May 22, 2013

RE: Fox Road Farm Short Plat SP-13-00001

Joe Gilbert  
Environmental Health Specialist II  
Kittitas County Public Health Department

FOX ROAD FARM SHORT PLAT  
PART OF SECTION 29, T. 18 N., R. 20 E., W.M.  
KITTITAS COUNTY, WASHINGTON

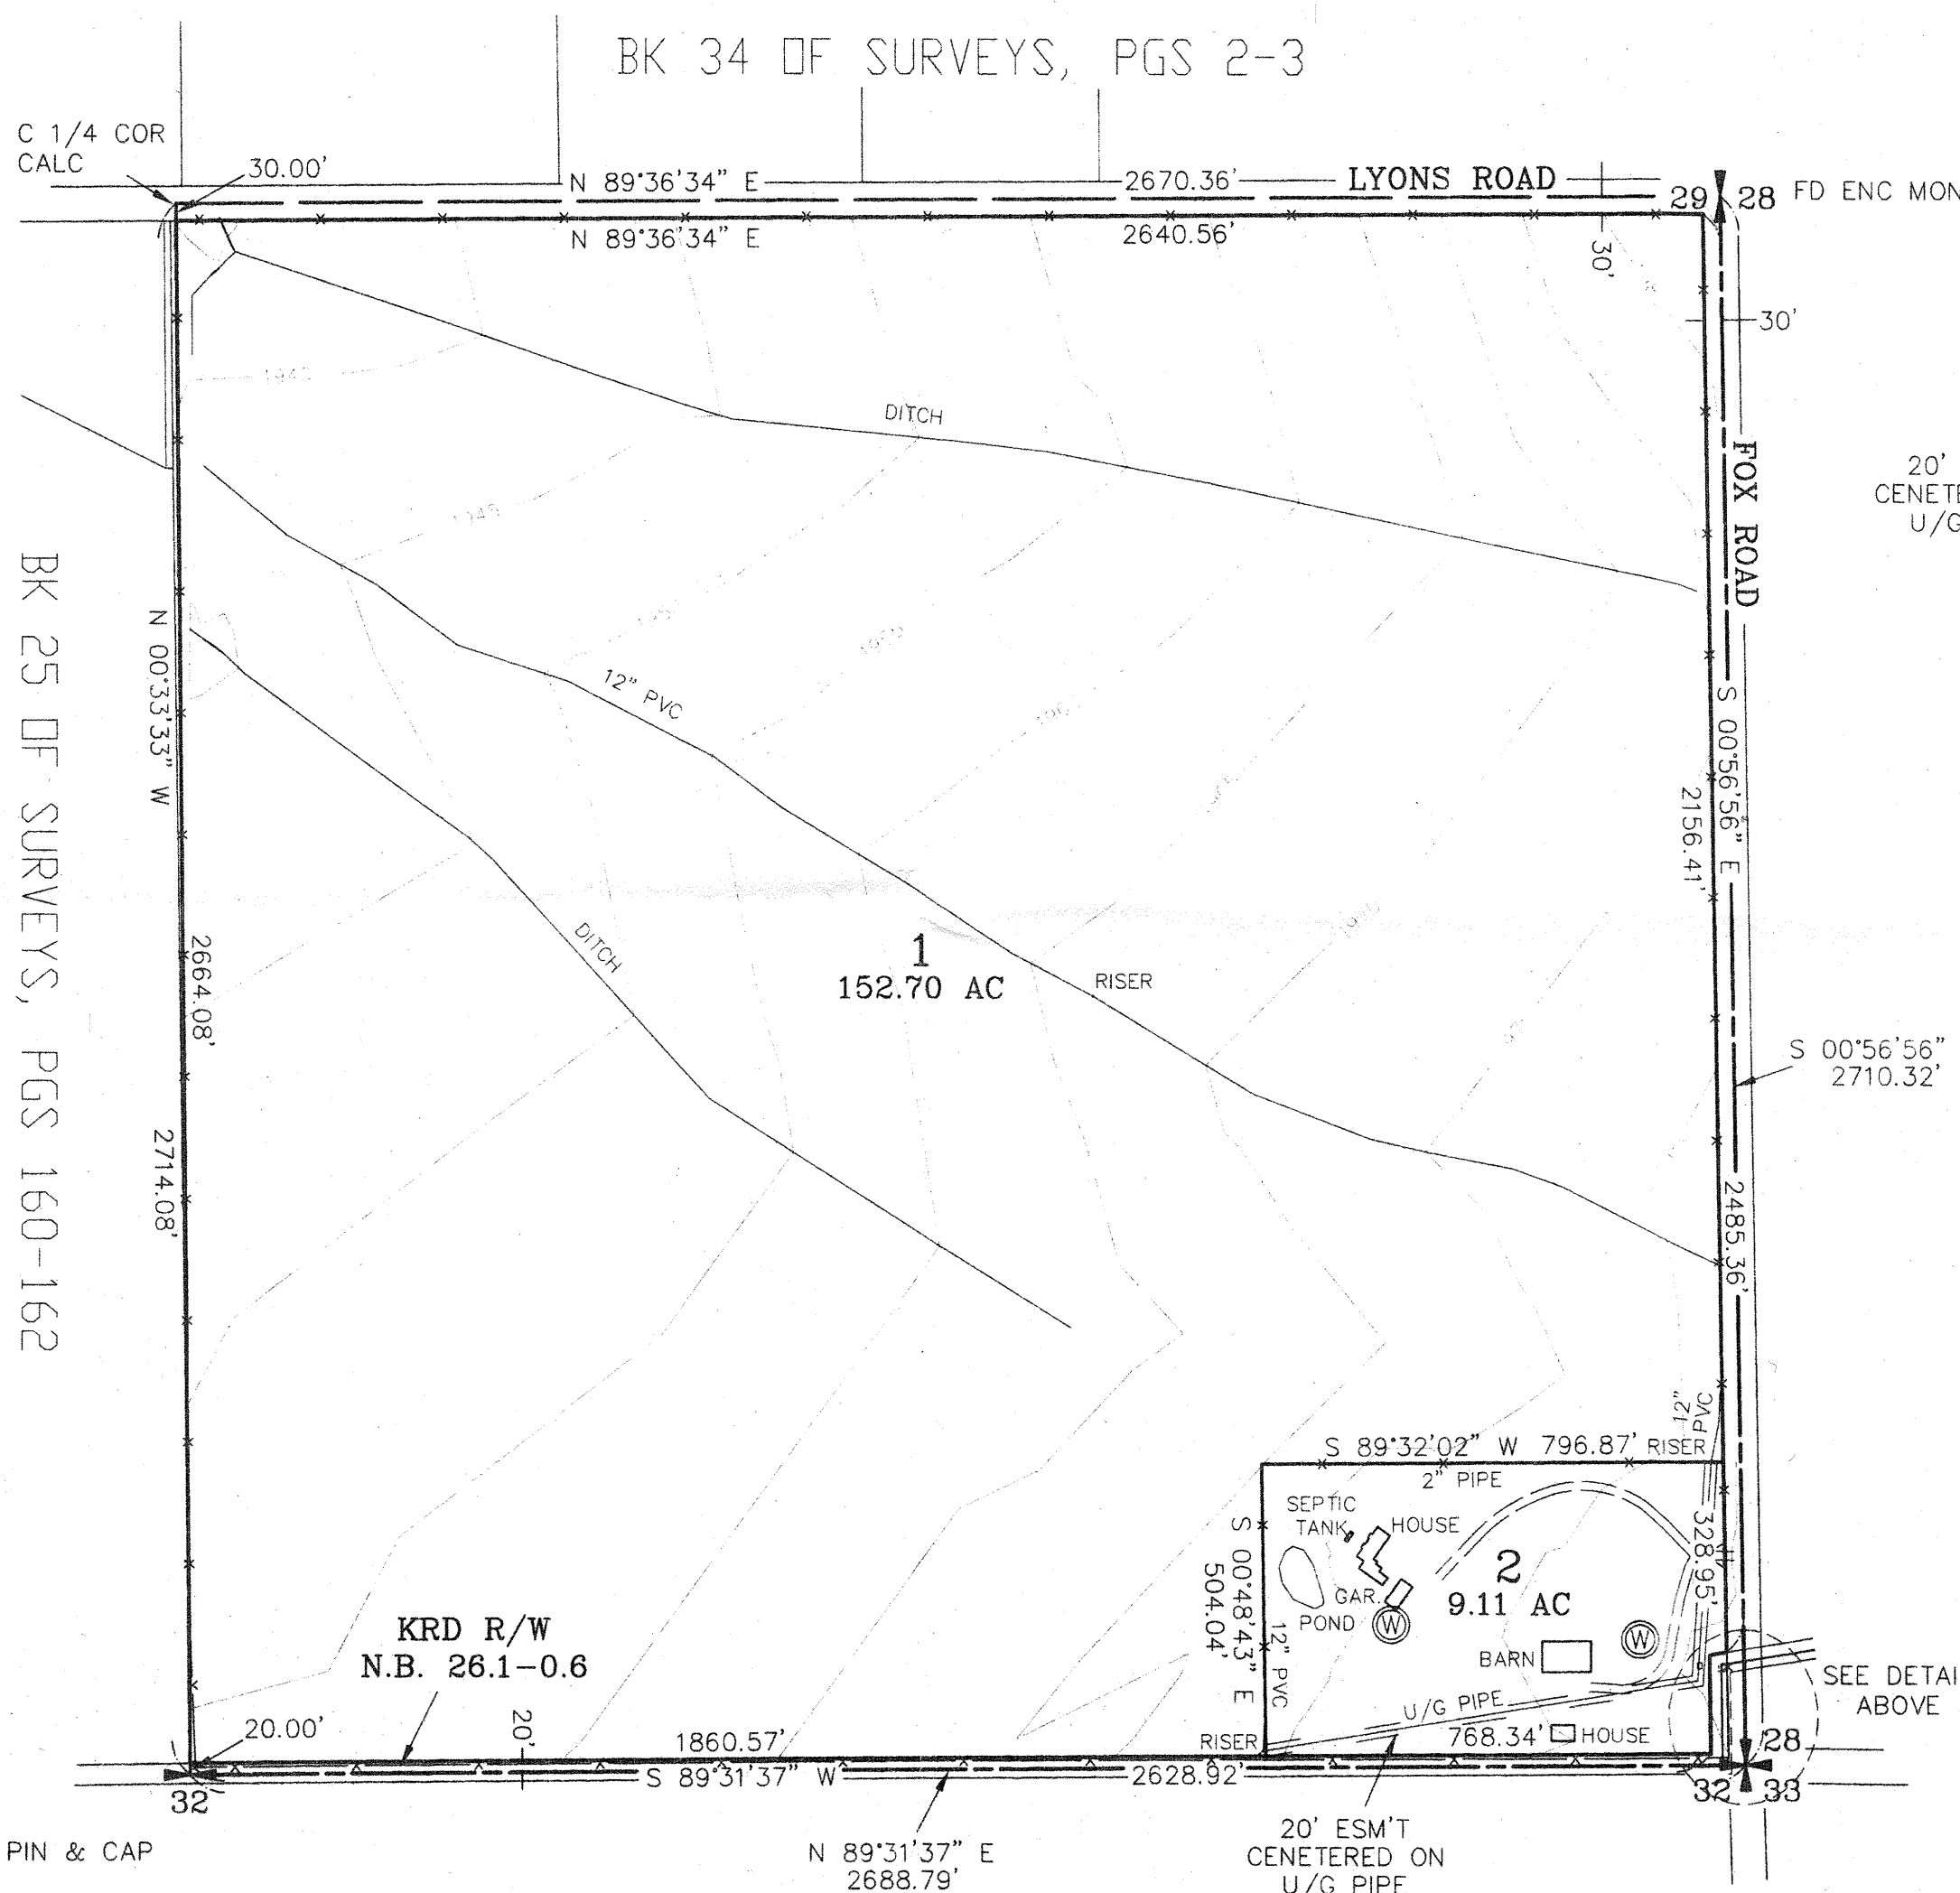
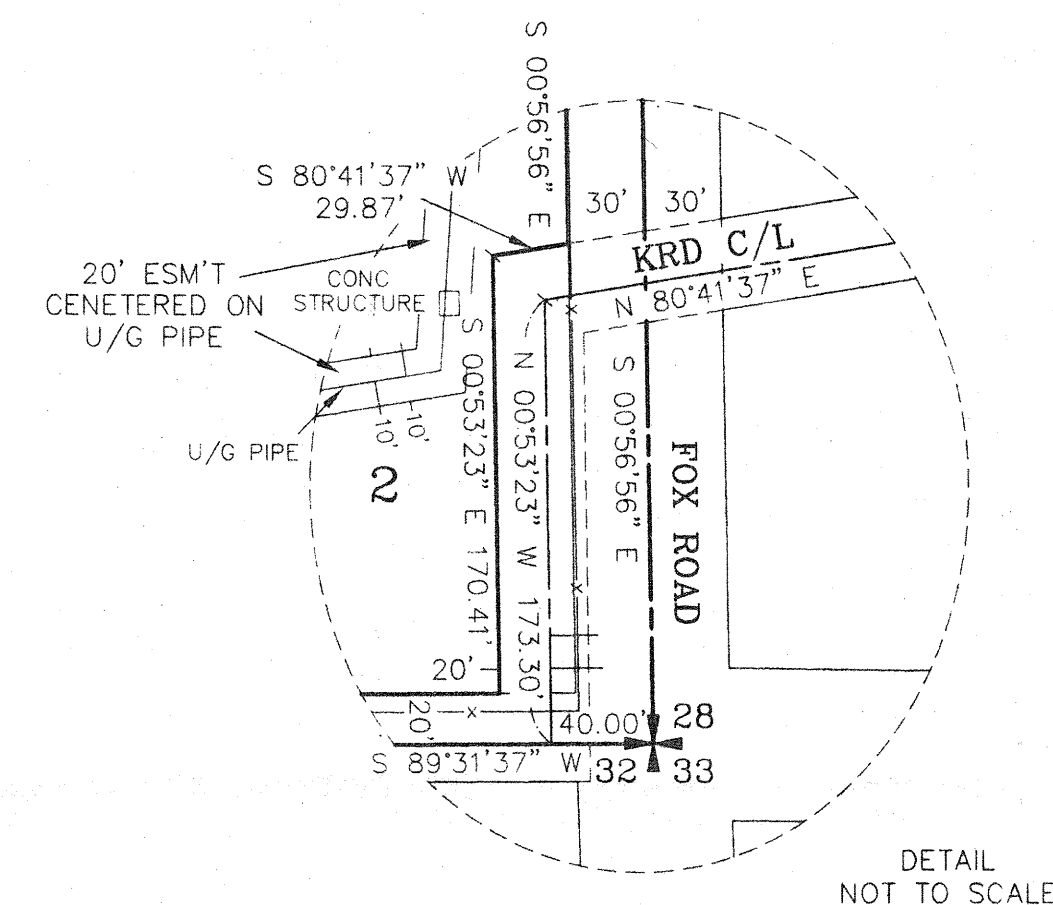
Since the proposed lot 2 already has a permitted septic system that lot will not require a soil log, you will only need to provide a soil log on the larger lot 1 located at your discretion as long as it makes 100'

setbacks from surface water. It appears that there are two wells located on lot 2, you will either need to drill a well on lot 1 or provide a recorded shared well users agreement supplying lot 1 from a well on lot 2. The above mentioned requirements need to be satisfied and the appropriate documentation needs to be submitted to KCPHD for review and approval in order for the plat application to be recommended for final approval.
